**WEST SUSSEX COUNTY COUNCIL
INFRASTRUCTURE CONSULTATION**

SUBJECT: R/49/09

8 Bushby Avenue, Rustington

House & detached garage (amendment to previously approved application)

GARAGE

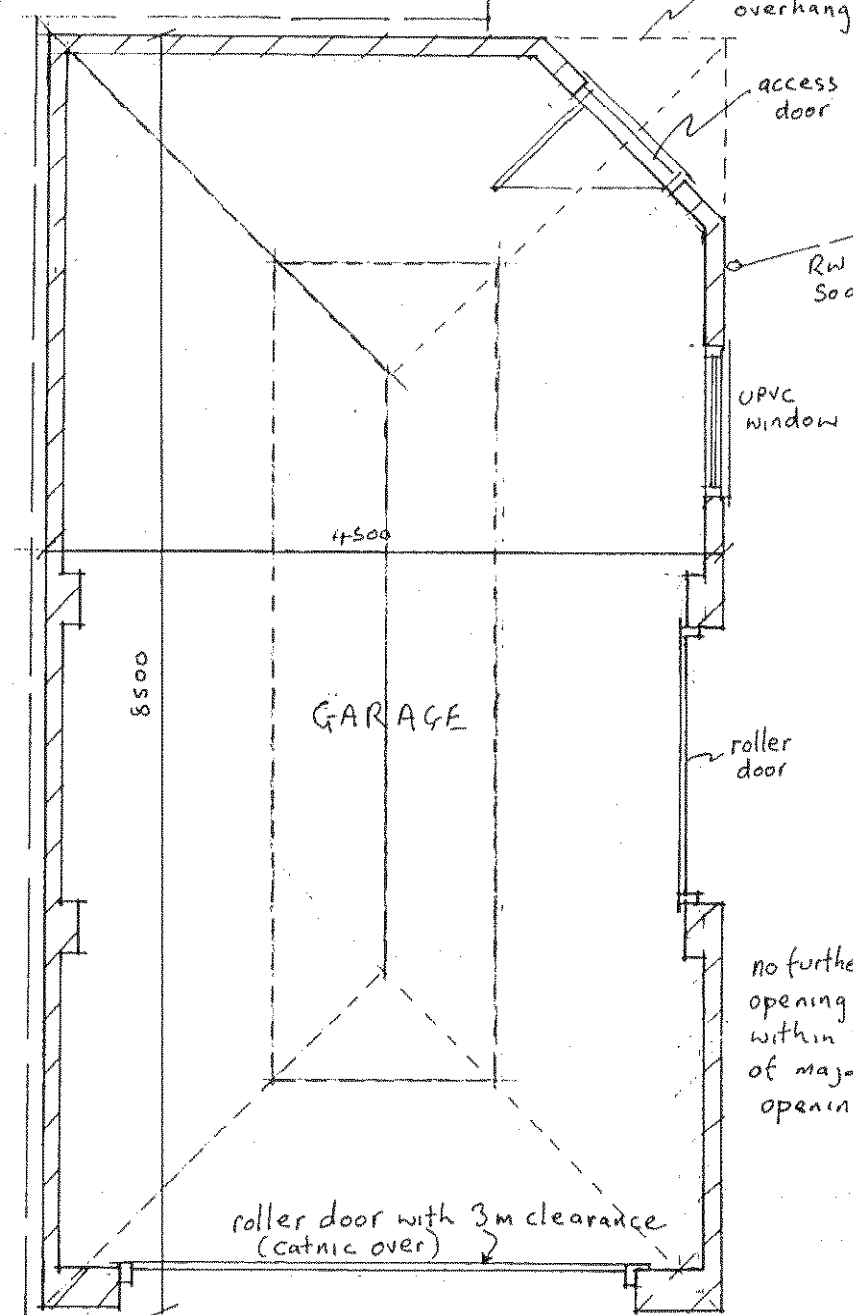
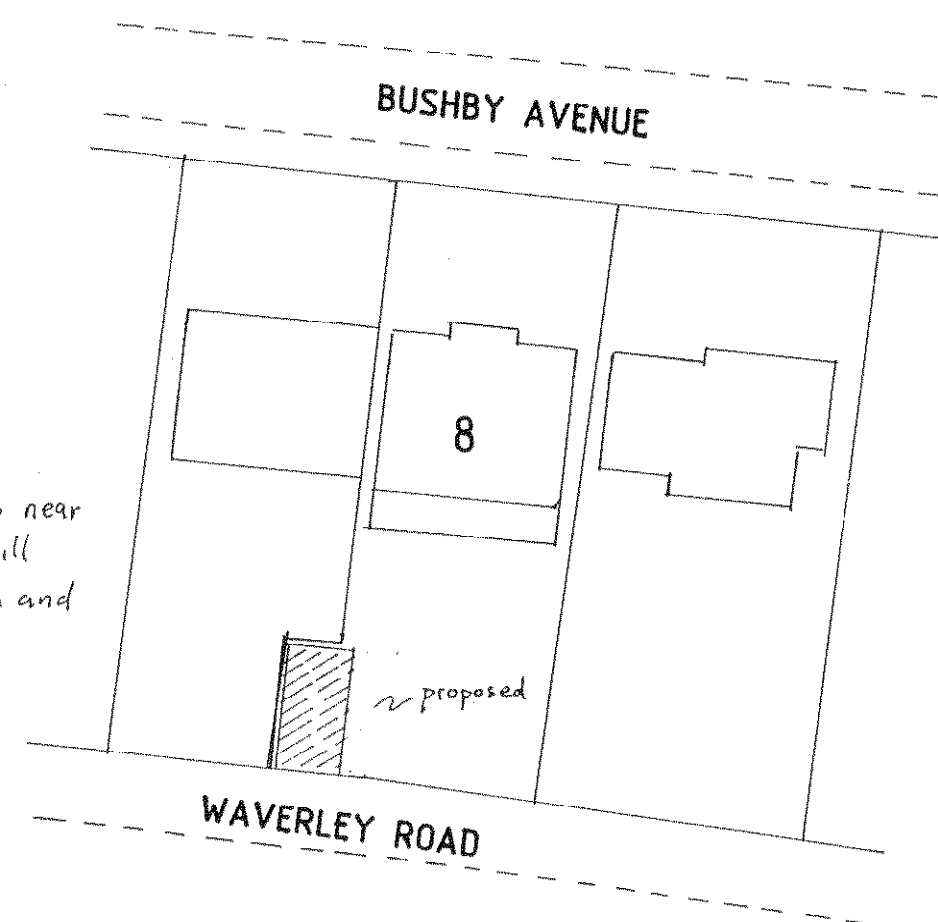
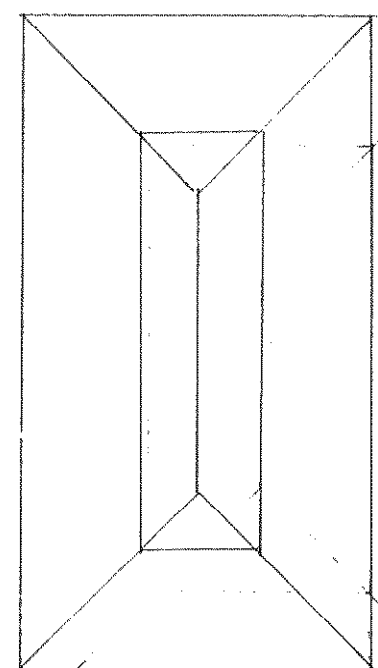
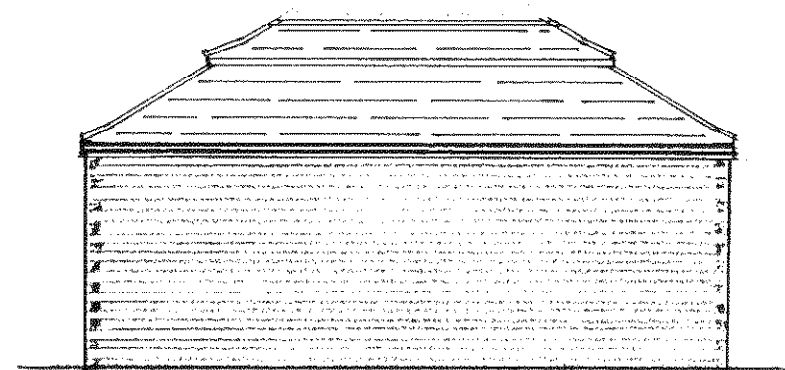
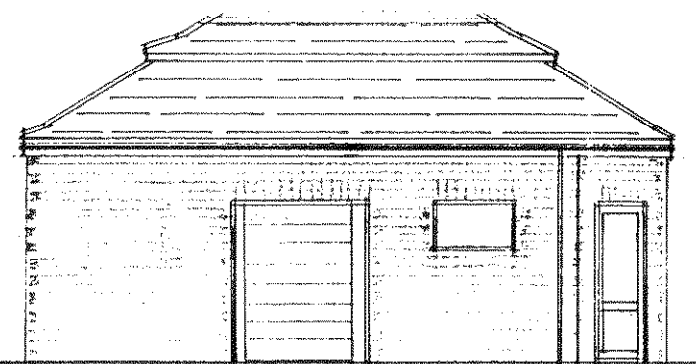
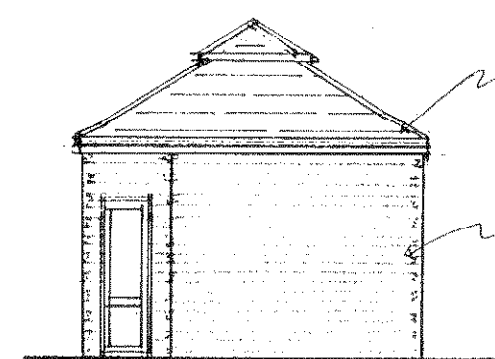
The newly submitted plans show that the proposed garage is to be constructed to a smaller size than in the previous application. This alteration is not anticipated to have an adverse affect on the public highway, and therefore the previous comments provided by WSCC (30/3/2009) should be referred to.
